27 January 2016

**Subject: Port Kembla Bulk Liquids Terminal (SSD 7264)
Notice of Exhibition**

Peter Green
General Manager
Port Kembla Coal Terminal

Figure 2.3 Terminal Layout and Emission Sources

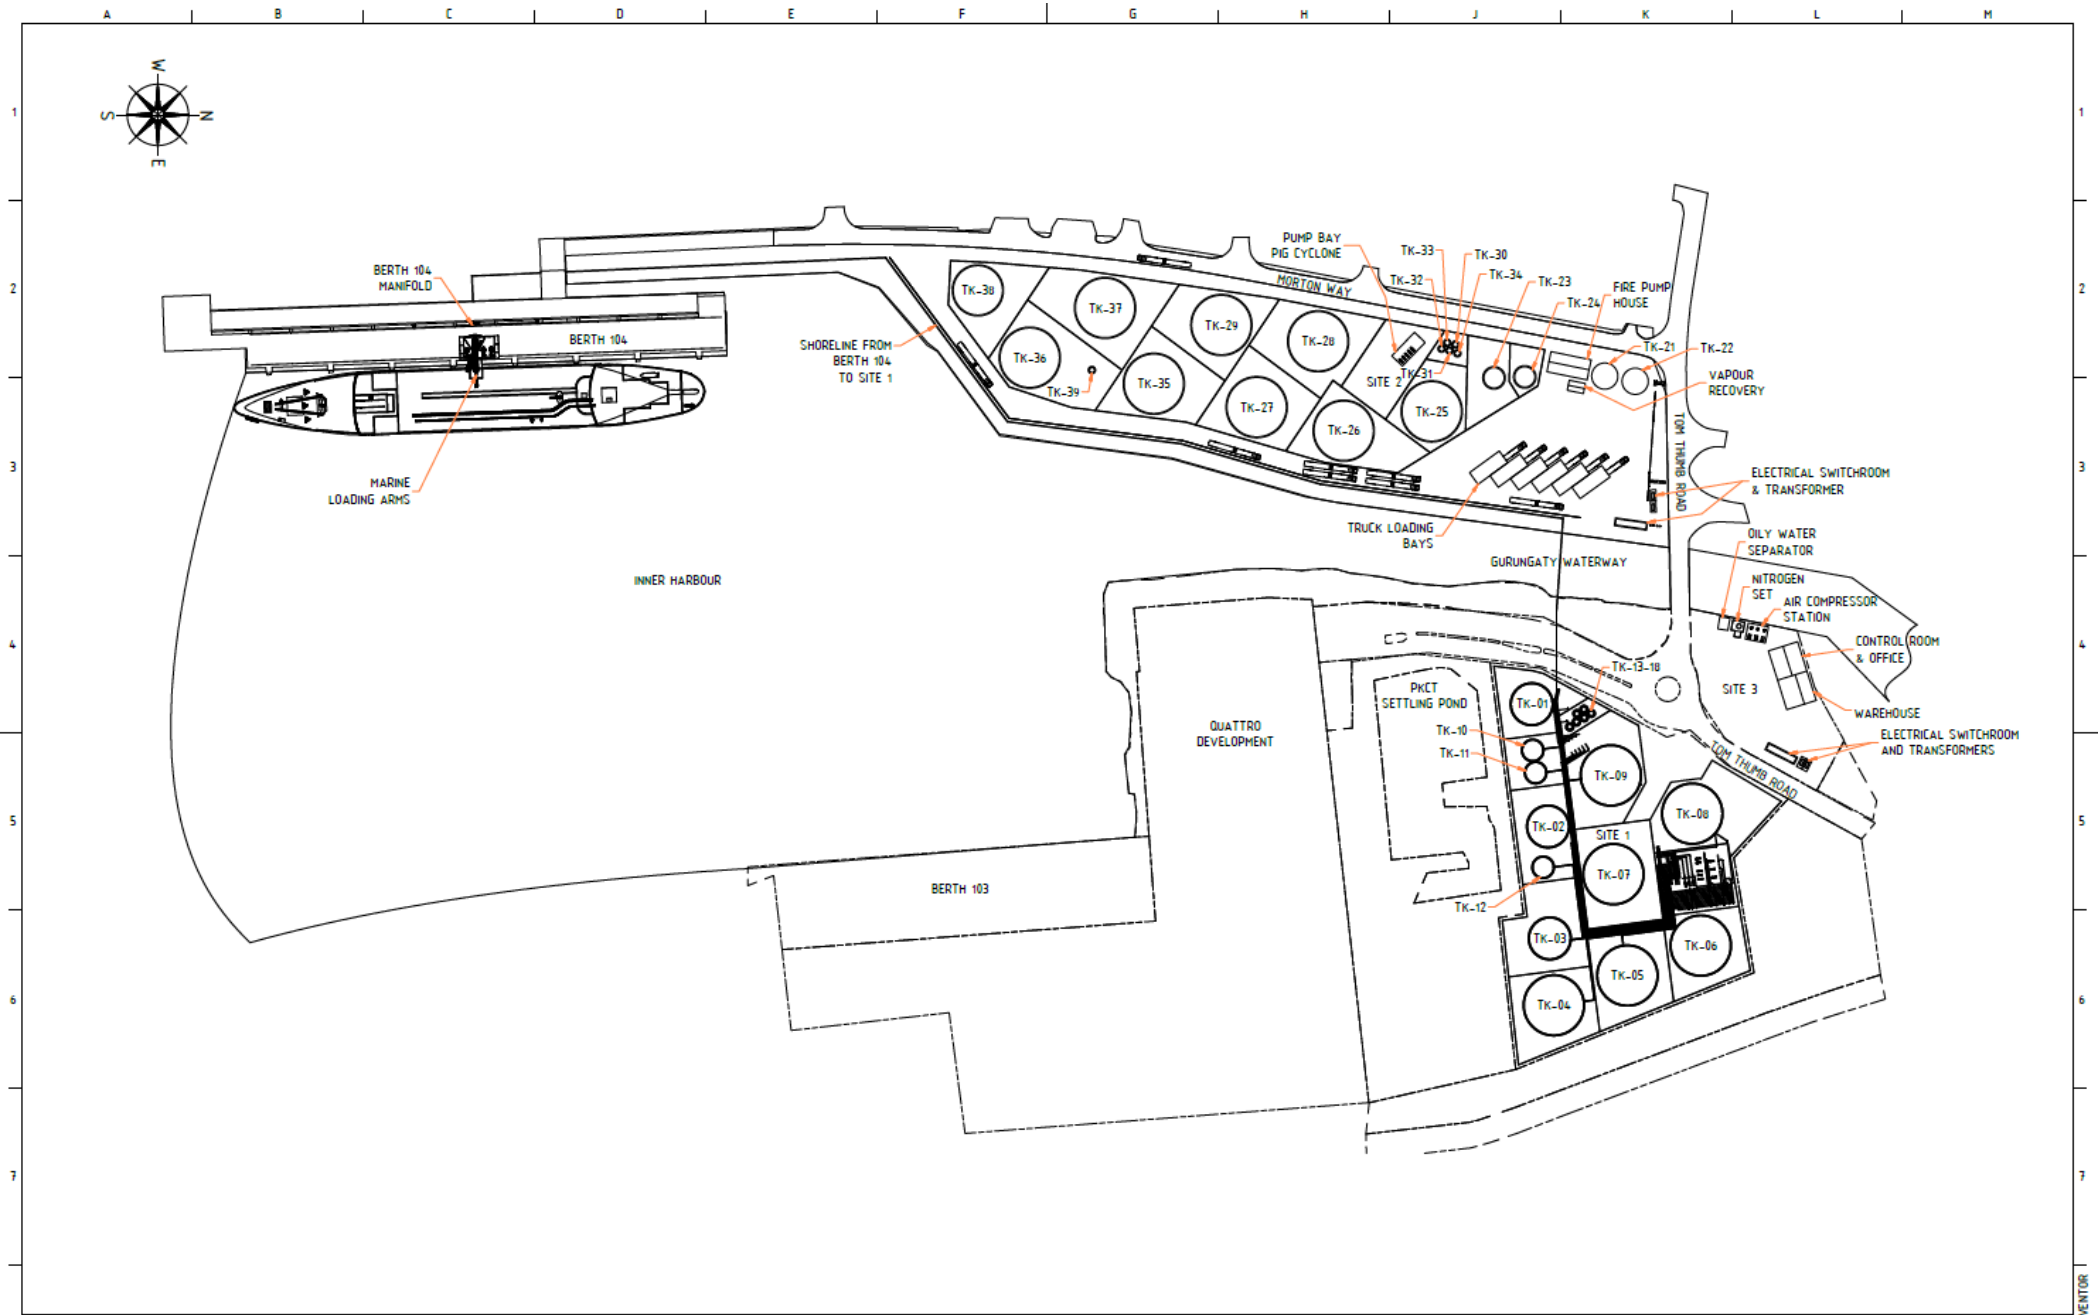
- 1) Show the thermal radiation isopleths at 12.6 and 23kW/m² for all the full bund fires on site 1. Show the assumed fire centres. Lay these over the area map to see potential thermal impacts on PKCT's northern stockpile areas and the PKCT operations area directly north of site 1.
- 2) Provide the LFL isopleth outlines for the major, full bund gasoline pool dispersions, giving some details of the surface roughness and other atmospheric and terrestrial assumptions.
- 3) Provide details of how TQ would mitigate the effects of full bund fire events as well as the potential generation of large flammable vapour clouds particularly in relation to impacts on the PKCT site to the east, north and south of the TQ site 1.
